Application for Planning Permission for Works or Extension to a Dwelling

Development: Proposed loft conversion and front porch.
Location: 94 Hook Lane Bognor Regis PO22 8AT

Proposed Loft Conversion Plans and Elevations Planning Date February 2026
Scale 1:200 1:1250

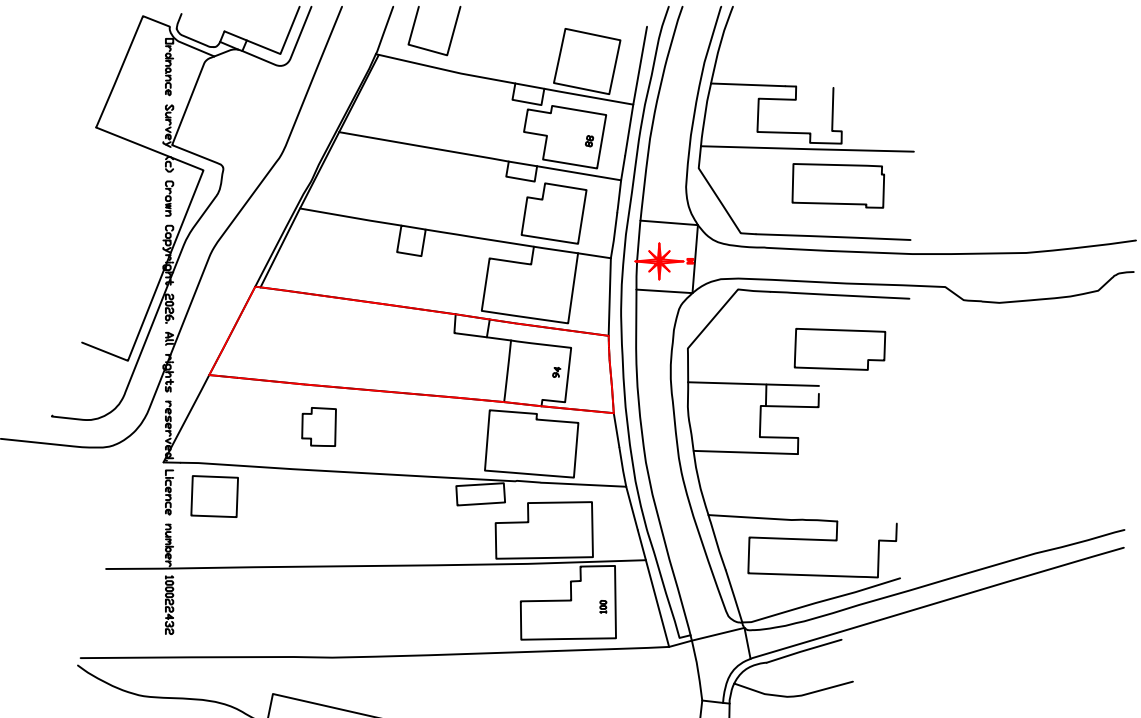
Block Plan

Please amend the block plan to show the proposed front porch.
